DEVIATION REQUEST AND DECISION FORM

Project Name :	Crossroads North
Schedule No.(s) :	5408001008, 5408001029, 5408001032, 5408001033, 5408001034, 5408001041, 5408001042, 5408001050, 5408001051, 5408001052
Legal Description :	LOTS 12, 13, 14, 15, 16 AND 18, HILLCREST ACRES, ACCORDING TO THE PLAT THEREOF RECORDED MAY 12, 1960 AT RECEPTION NO. 153860, EXCEPT THAT PORTION ACQUIRED BY THE DEPARTMENT OF TRANSPORTATION, STATE OF COLORADO AS DESCRIBED IN RULE AND ORDER RECORDED APRIL 28, 2004 UNDER RECEPTION NO. 204068322, AND EXCEPT THOSE PORTIONS CONVEYED TO EL PASO COUNTY BY AND THROUGH THE BOARD OF COUNTY COMMISSIONERS OF EL PASO COUNTY, COLORADO BY SPECIAL WARRANTY DEED RECORDED DECEMBER 17, 2014 AT RECEPTION NO. 214116021 AND RECORDED DECEMBER 17, 2014 AT RECEPTION NO. 214116022, COUNTY OF EL PASO, STATE OF COLORADO. LOT 17, HILLCREST ACRES, COUNTY OF EL PASO, STATE OF COLORADO, EXCEPT THAT PORTION CONVEYED TO EL PASO COUNTY BY AND THROUGH THE BOARD OF COUNTY COMMISSIONERS OF EL PASO COUNTY, COLORADO BY SPECIAL WARRANTY DEED RECORDED DECEMBER 30, 2014 AT RECEPTION NO. 214119767. LOT 19, HILLCREST ACRES, COUNTY OF EL PASO, STATE OF COLORADO, AS AMENDED BY SURVEYOR'S STATEMENT RECORDE

TYPICAL SEMPER SUPRA POINT (PRVT) 36' MAT
(STRIPED MEDIAN)

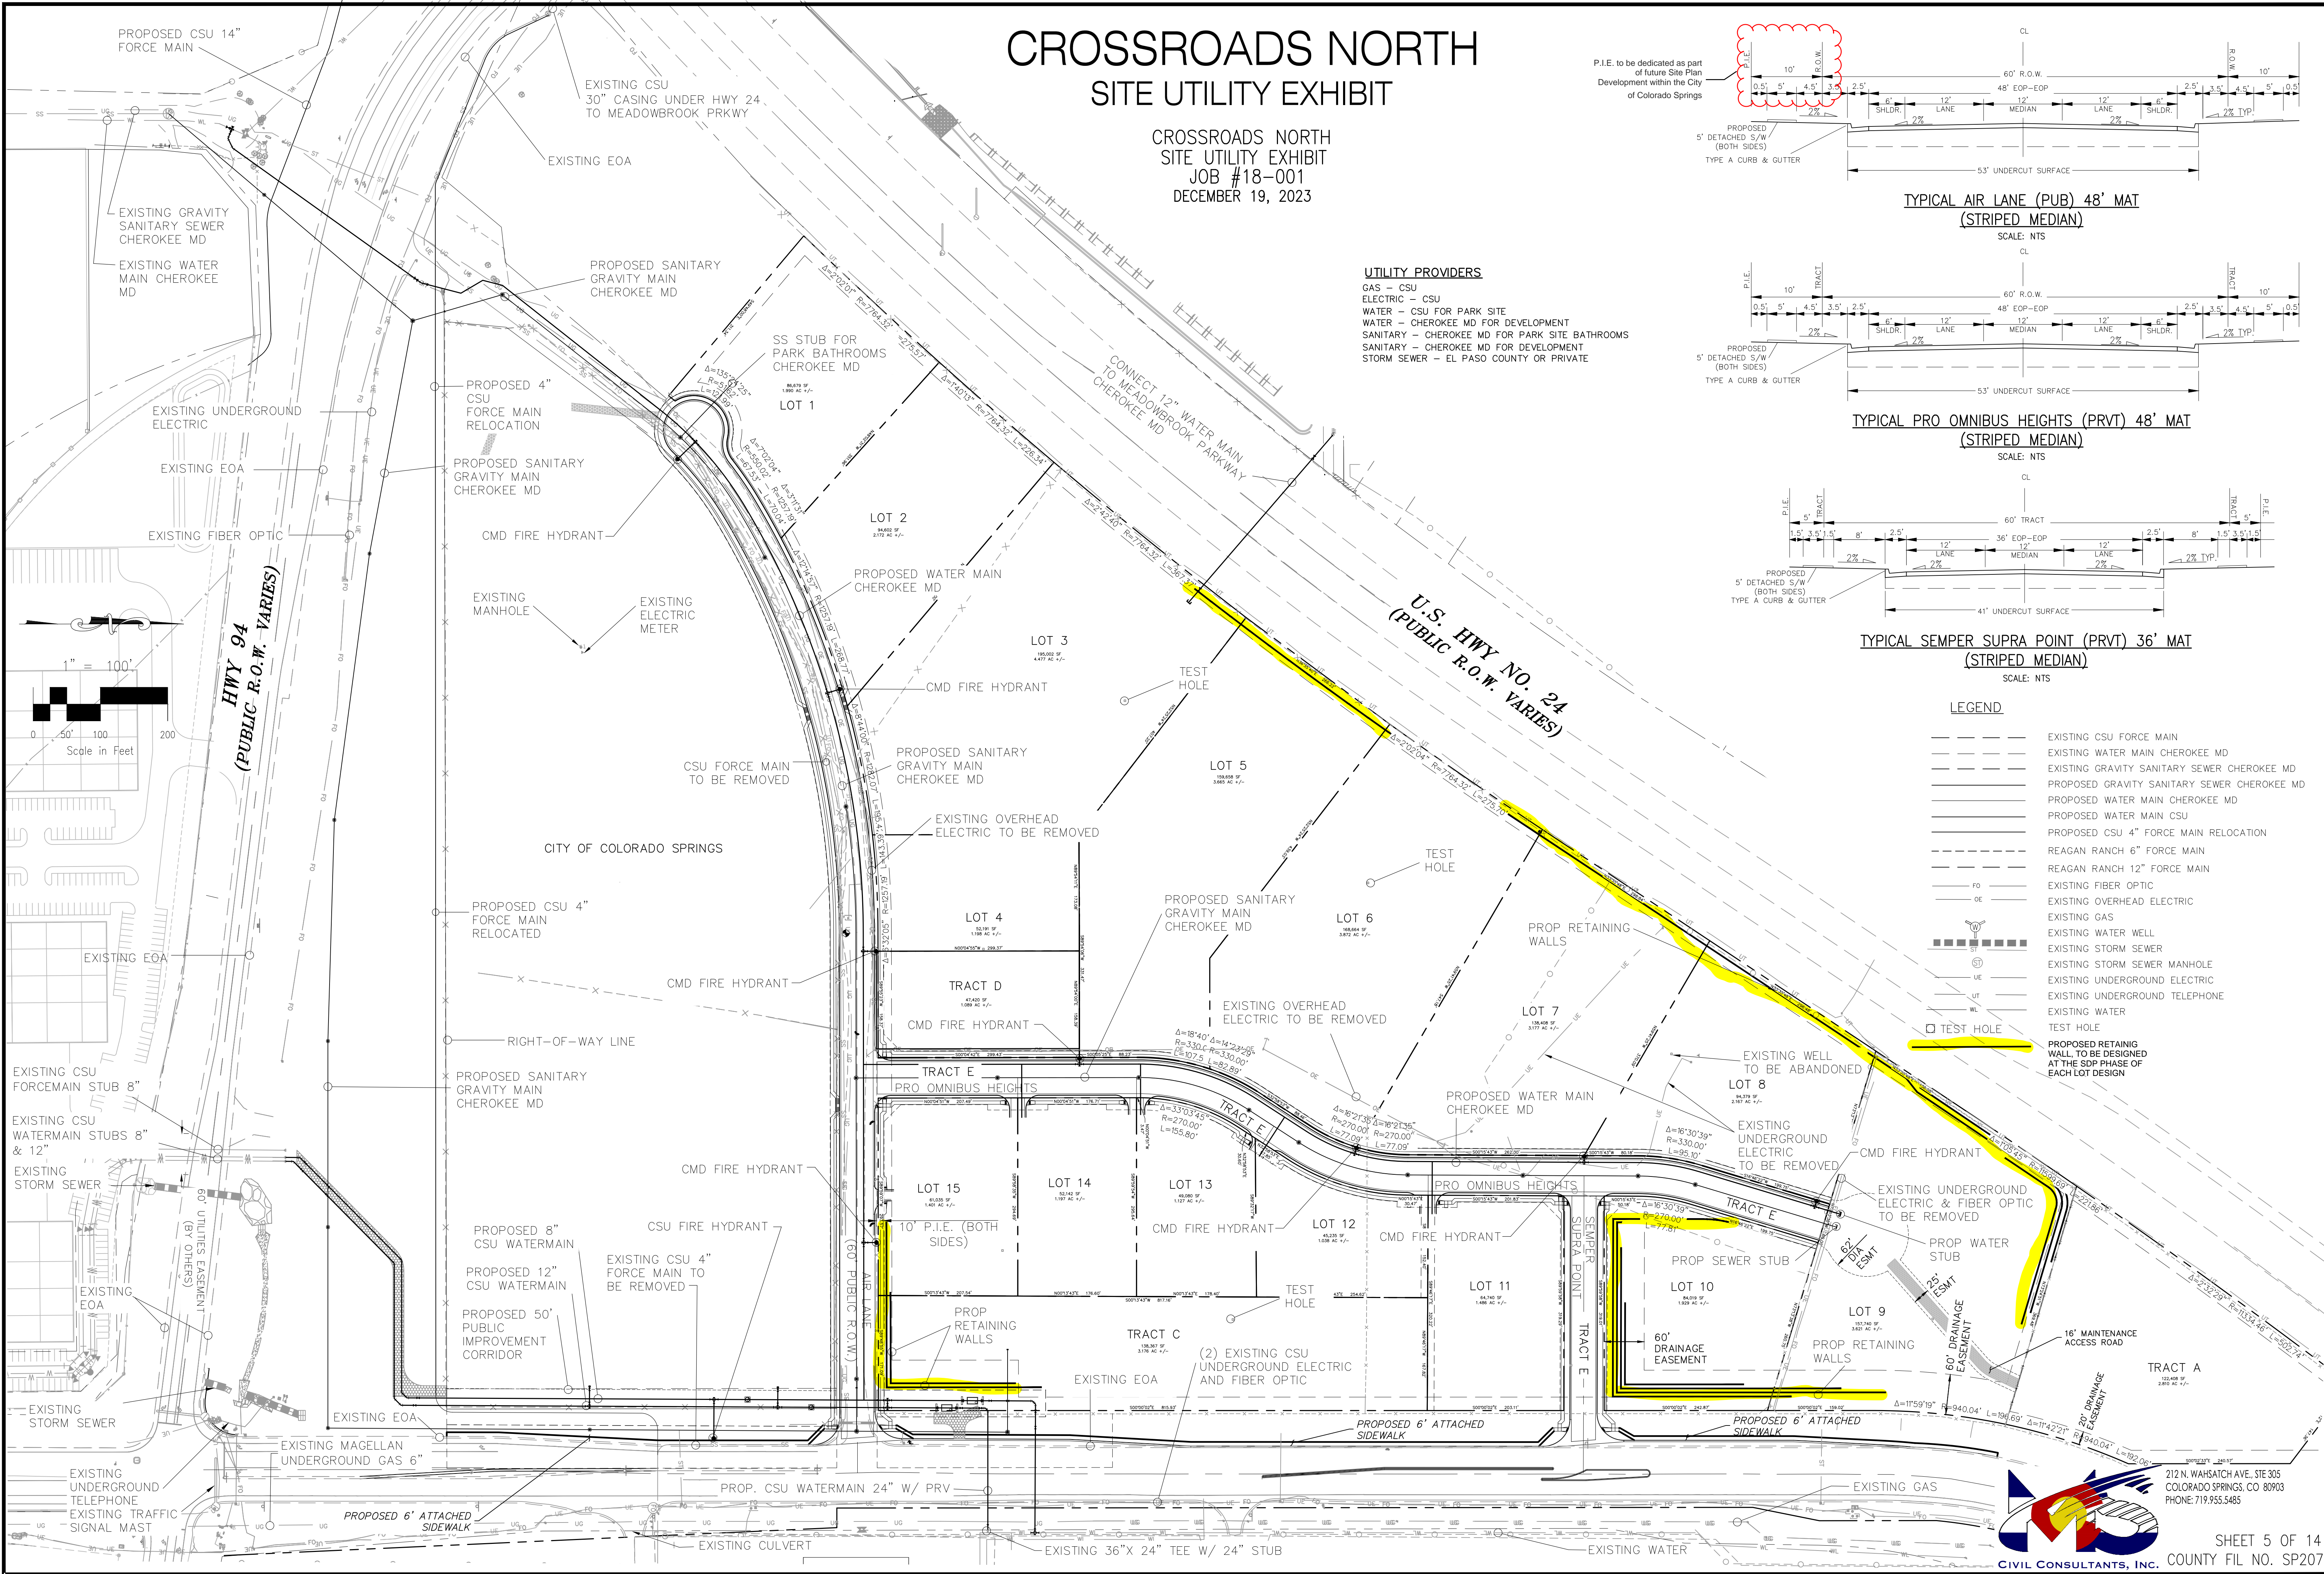
Please update the names as the prelim plan sheets and the grading plan road names do not match.

Additionally, only the east/west private roadway needs a deviation as the north/south roadway meets the standard urban non-residential collector roadway cross section per sheet 5 of the prelim plan. The LDC private road waiver allows for ROW width modification in LDC 8.4.4.E and it appears that that is the only change requested for the north/south roadway which is covered in the LDC waiver.

Revise the deviation to only include the roadway (east/west roadway) that is deviating from the standard. Per conversation with Engineering manager, staff is not against this deviation but information should be accurate. See comment below

Please clarify the tract width proposed as the prelim plan identifies an 80' easement for the north/south road and a 70' easement for the east/west road. revise as necessary for consistency.
